**KIRKLEES METROPOLITAN COUNCIL
INVESTMENT & REGENERATION SERVICE**

DELEGATED DECISION TO DETERMINE PLANNING APPLICATIONS

Reference No: 2019/62/93605/E

Site Address: April Court, Roberttown, Liversedge, WF15 7RB

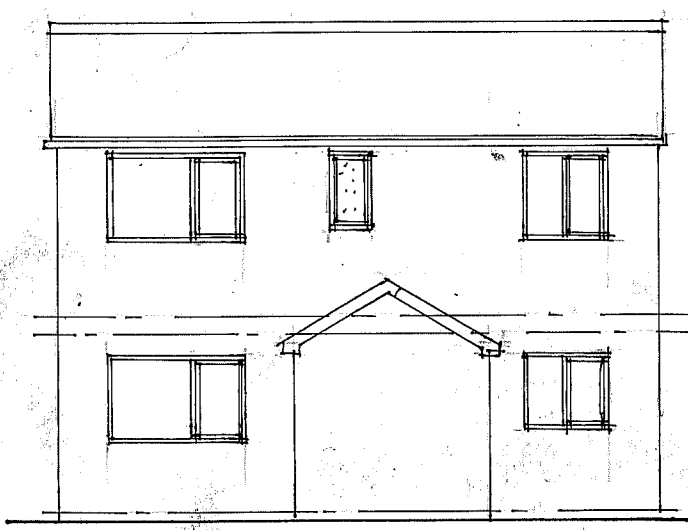
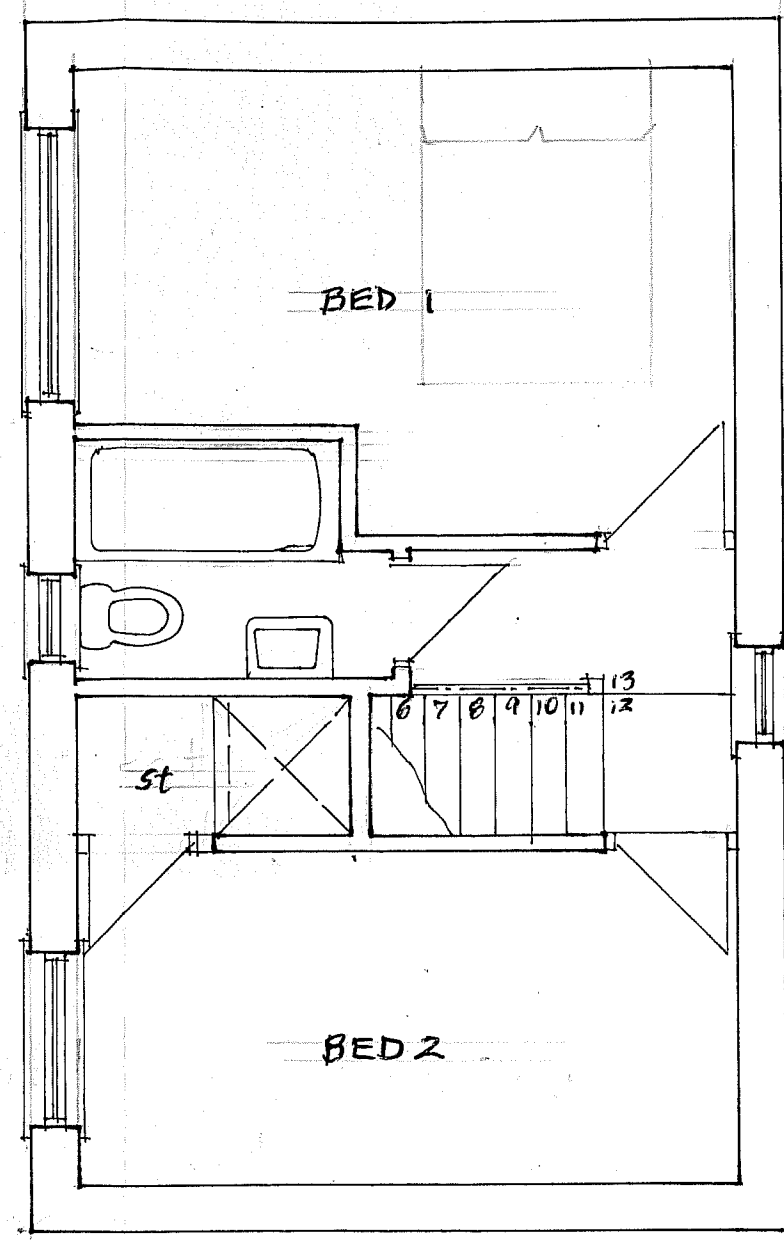
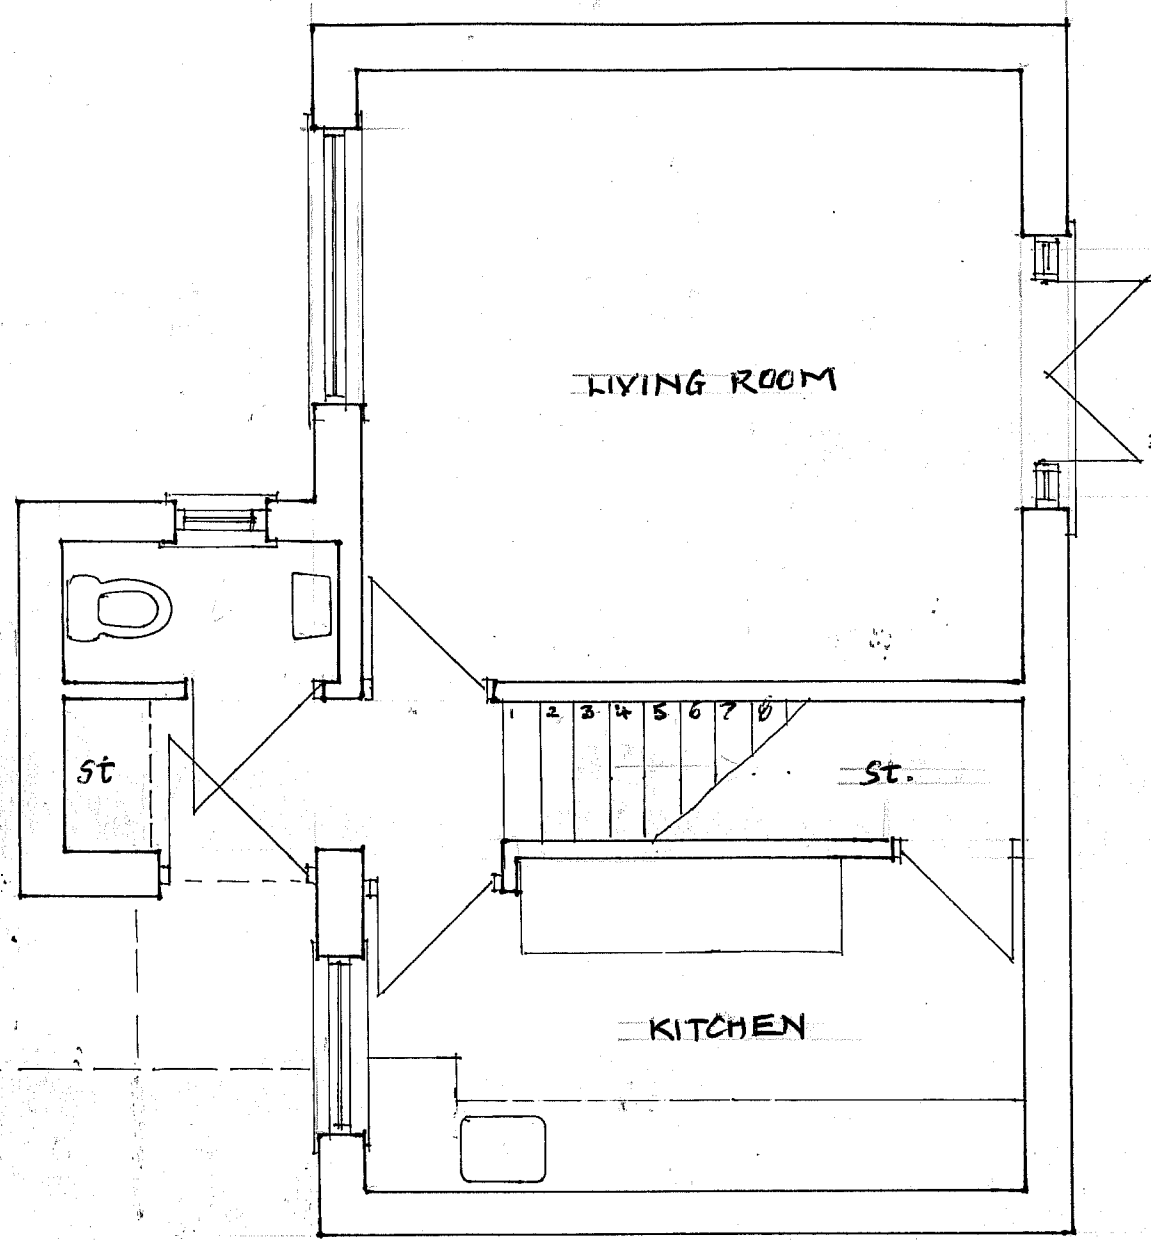
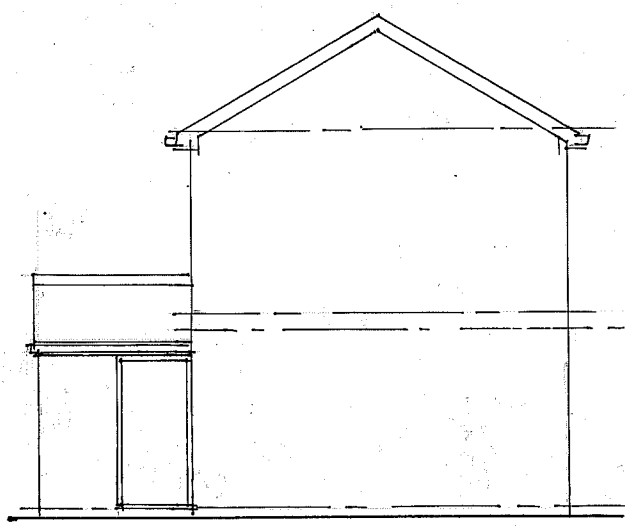
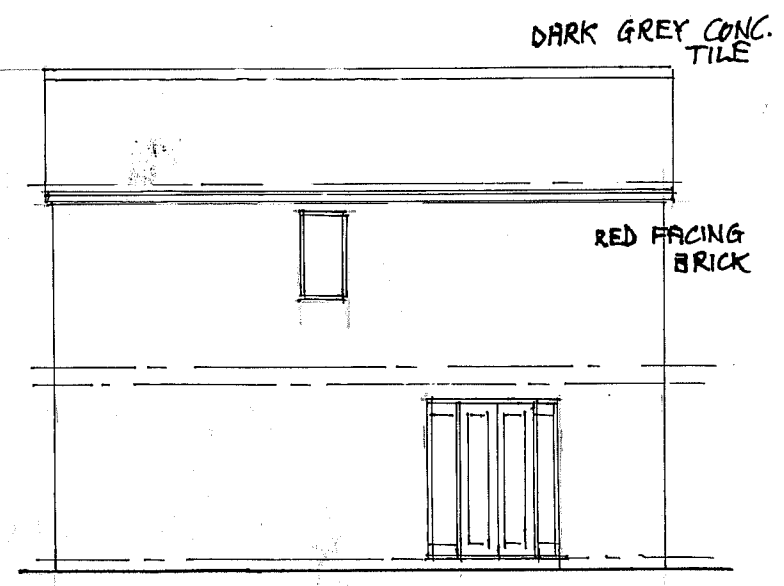
In terms of overlooking/loss of privacy, there are habitable-room windows at ground floor level and a first-floor window facing to the rear – this is serving a landing and is, therefore, considered non-habitable. The ground floor windows will be screened. A condition has been recommended to ensure that no future openings are inserted in the rear elevation of the dwelling, if approved. This is to ensure that there would be no future overlooking potential.

8. Notwithstanding the provisions of the Town and Country Planning (General Permitted Development) Order 2015 as amended (or any Order revoking or re-enacting that Order) no doors, windows or any other openings (apart from any expressly allowed by this permission) shall be created in the rear elevation of the dwelling hereby approved.
